Project Title: TRAILS UNIT 3A DMP PONDS (VALLE PRADO UNITS 1 AND 2) Building Permit #: \_\_\_\_\_ City Drainage #: \_\_\_\_\_

**RE: Trails Unit 3A DMP Ponds  
Valle Prado Units 1&2 (File: C09D011W)  
Grading Plan, Engineer's Stamp Date 9-16-2014**

Based upon the information provided in your submittals received 9-16-14, the above referenced plan is approved for Grading Permit with the following condition:

CITY OF ALBUQUERQUE	
		PUBLIC WORKS DEPARTMENT	
TRAILS UNIT 3A DMP PONDS			
POND D1			
GRADING PLAN			
Design Review Committee	City Engineer Approval	Mo./Day/Yr.	Mo./Day/Yr.
City Project No.	Zone Map No.	Sheet	Of
XXXXXX	C-09-Z	2	5

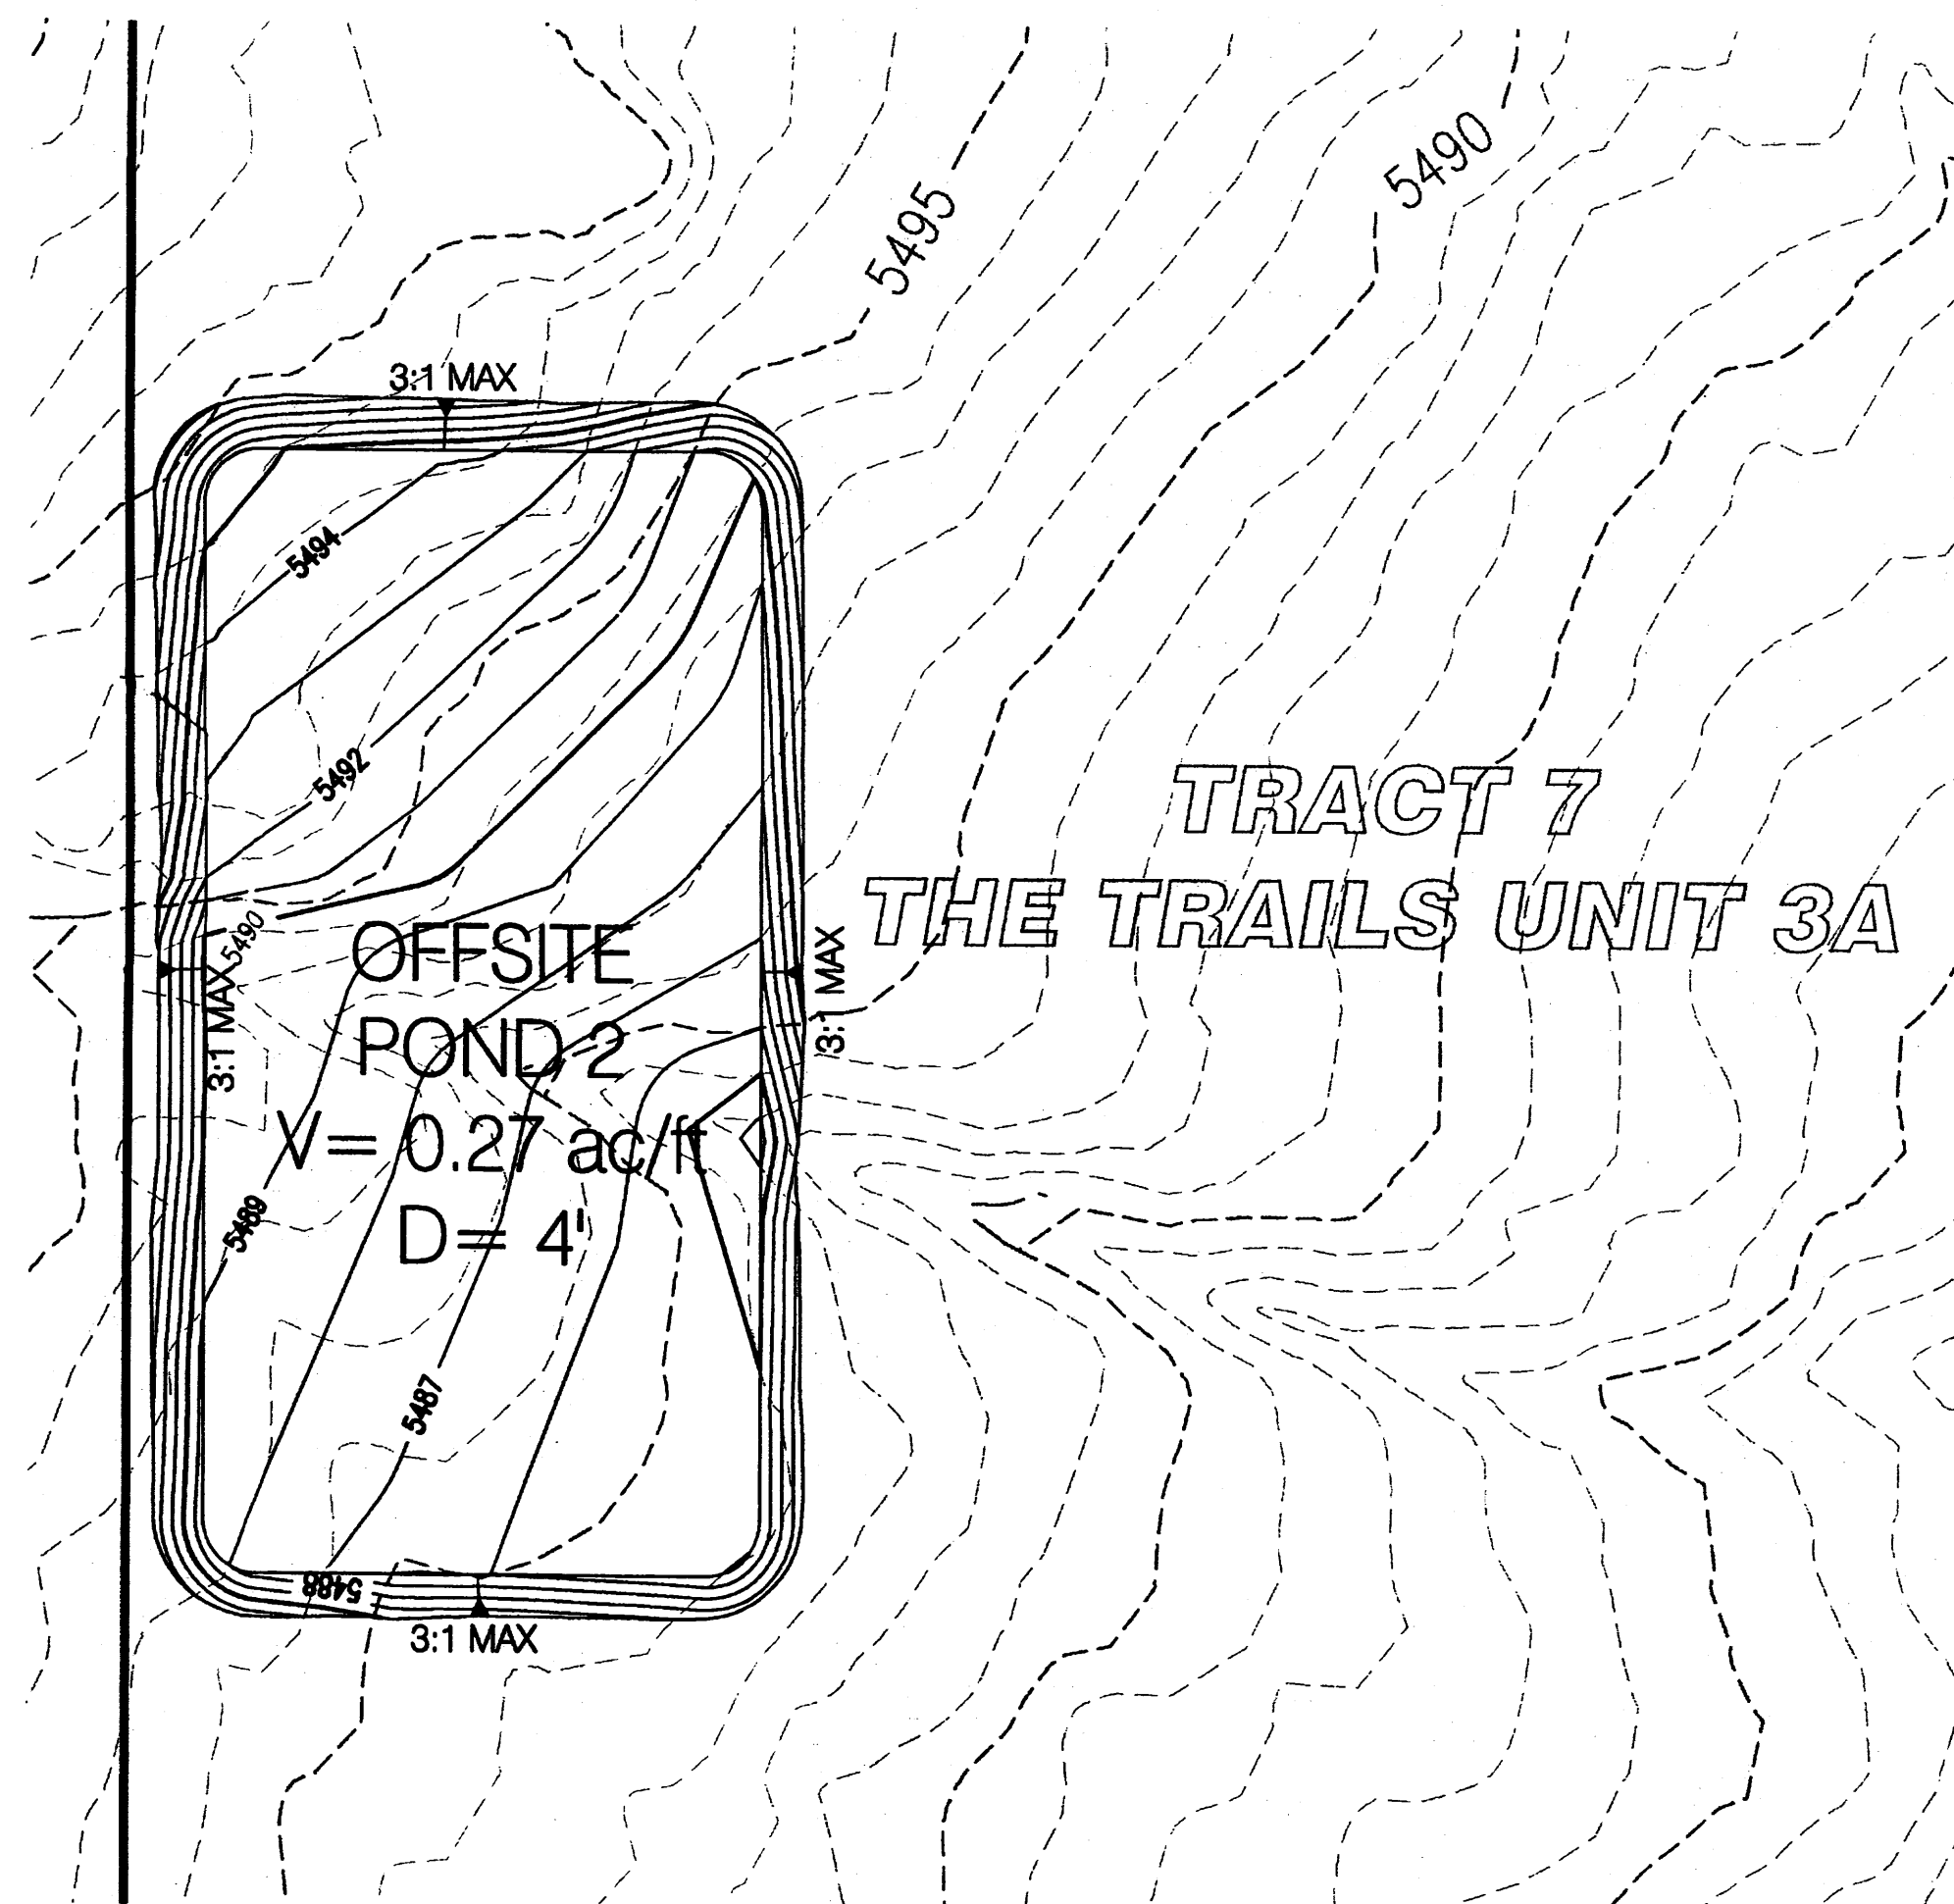
- 1) Detailed design of standpipe in Pond D1 will be submitted after the pond is graded, and will be designed per as-built condition.
